**WELWYN HATFIELD BOROUGH COUNCIL
EXECUTIVE DIRECTOR - PLANNING, PUBLIC PROTECTION AND GOVERNANCE**

Application No: 6/2021/2816/HOUSE
Location: 53 High Road Essendon Hatfield AL9 6HS
Proposal: Extension of existing dropped curb
Officer: Ms Ashley Ransome

Recommendation: Refused

PROPOSED PLAN WITH EXTENDED
DROPPED KERB & BUSH REMOVAL

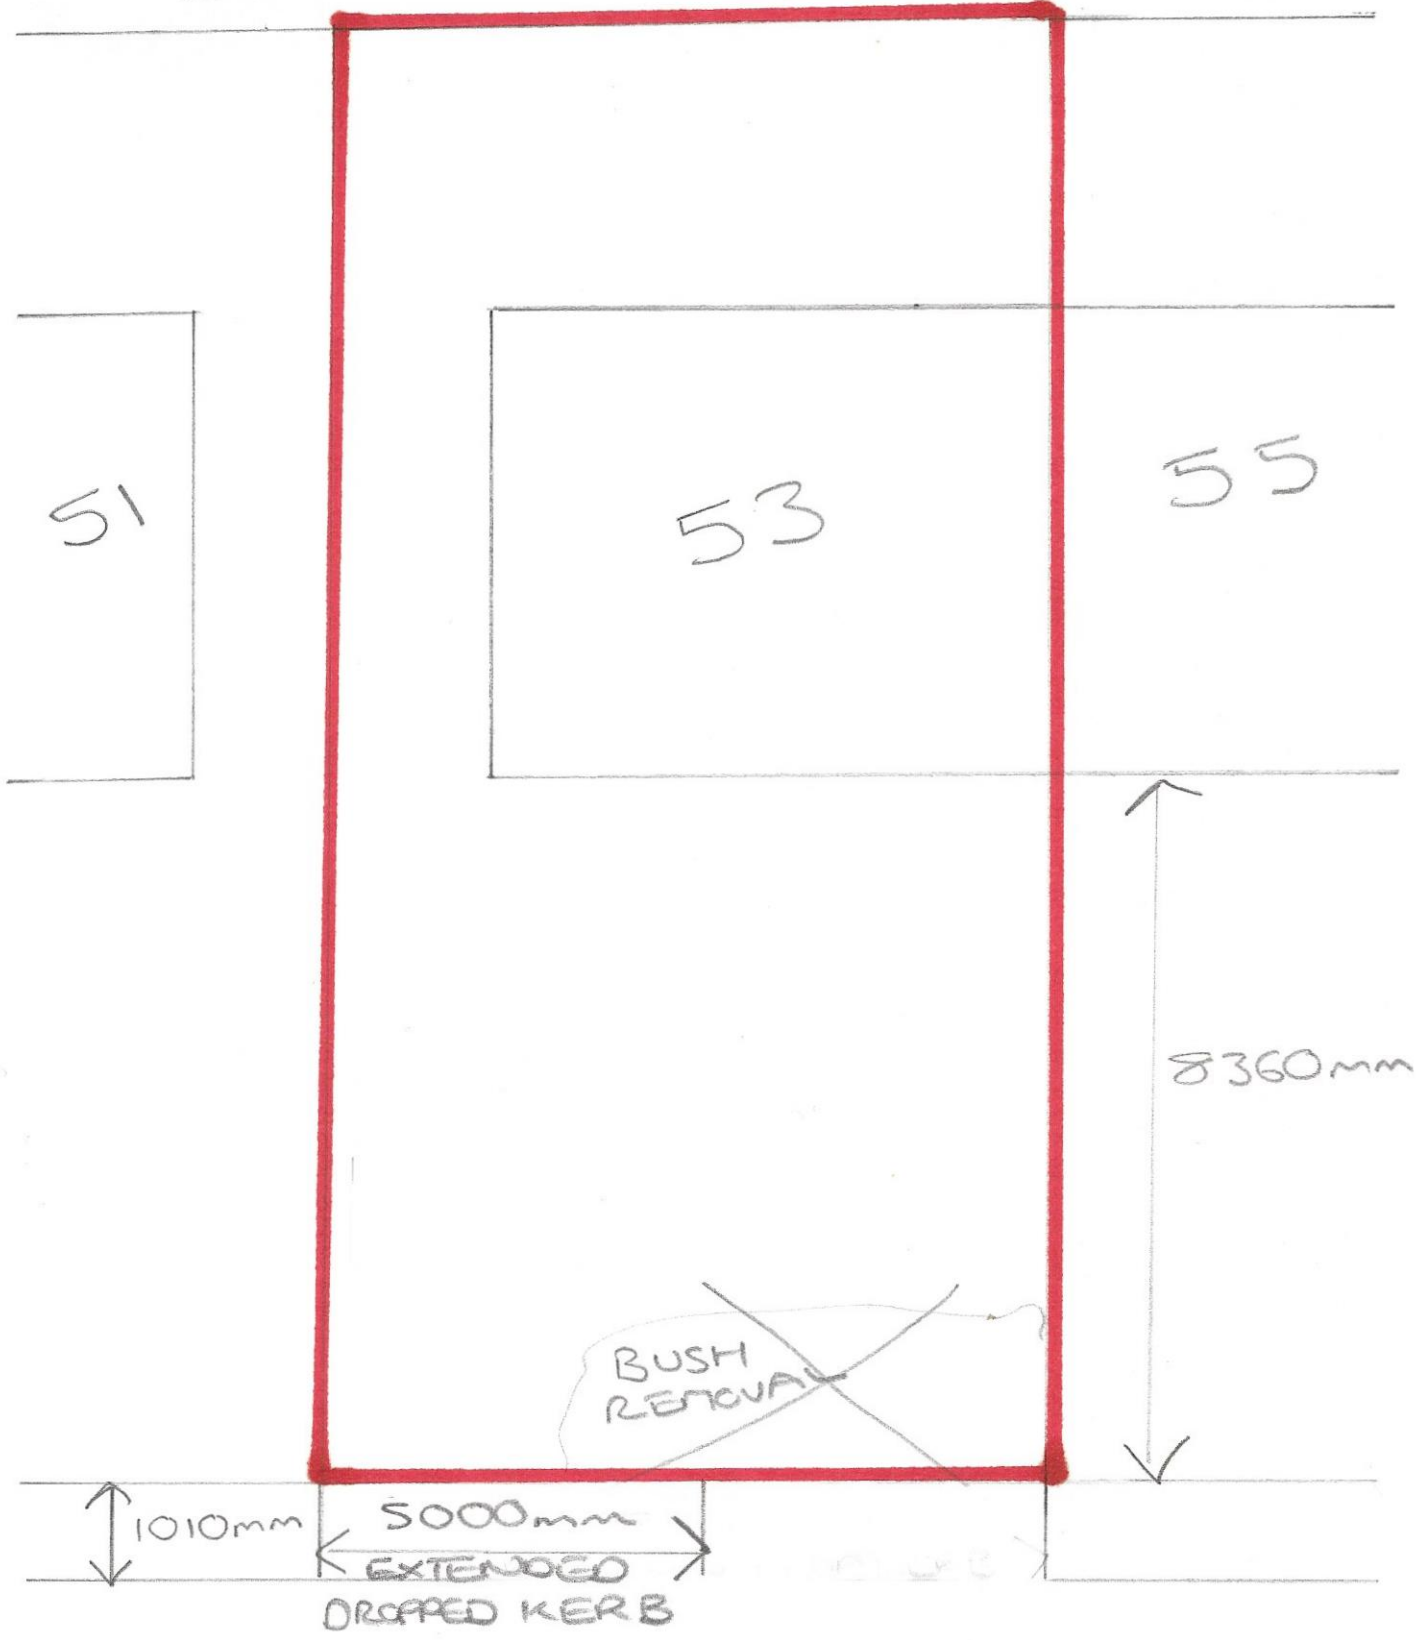
2016, the Welwyn Hatfield Supplementary Design Guidance 2005 and the National Planning Policy Framework 2021.
Access, car parking and highway considerations	<p>With the amendments made within the application seeing a reduction in the width of the proposed dropped kerb, the previous objection by the Highway Authority has been overcome and they now do not wish to restrict the grant of permission. Informatives have been advised to be included upon any grant of permission.</p> <p>With regards to parking, the proposed development will increase the provision of off-street parking for the application site. However, this does not mitigate the harmful impact the proposal has upon the character and appearance of the Conservation Area.</p>
Conclusion	
For the reasons set out above, the proposed development does not accord with the relevant policies, thus is not acceptable in terms of the impact upon the character and appearance of the Essendon Conservation Area. It is therefore recommended that planning permission is refused.

1. The proposed development would not preserve or enhance the character and appearance of the surrounding street scene or the Conservation Area, as per Section 72 (1) of the Planning (Listed Buildings and Conservation Areas) Act 1990. It would result in some 'less than substantial' harm to the significance of the Conservation Area and the proposal would not pose any public benefits to outweigh the harm identified. Accordingly, the proposed development represents a poor standard of design and is therefore contrary to Policies D1 and D2 of the Welwyn Hatfield District Plan 2005, Policies SP9 and SADM15 of the Welwyn Hatfield Draft Local Plan 2016, the Welwyn Hatfield Supplementary Design Guidance 2005 and the National Planning Policy Framework 2021.
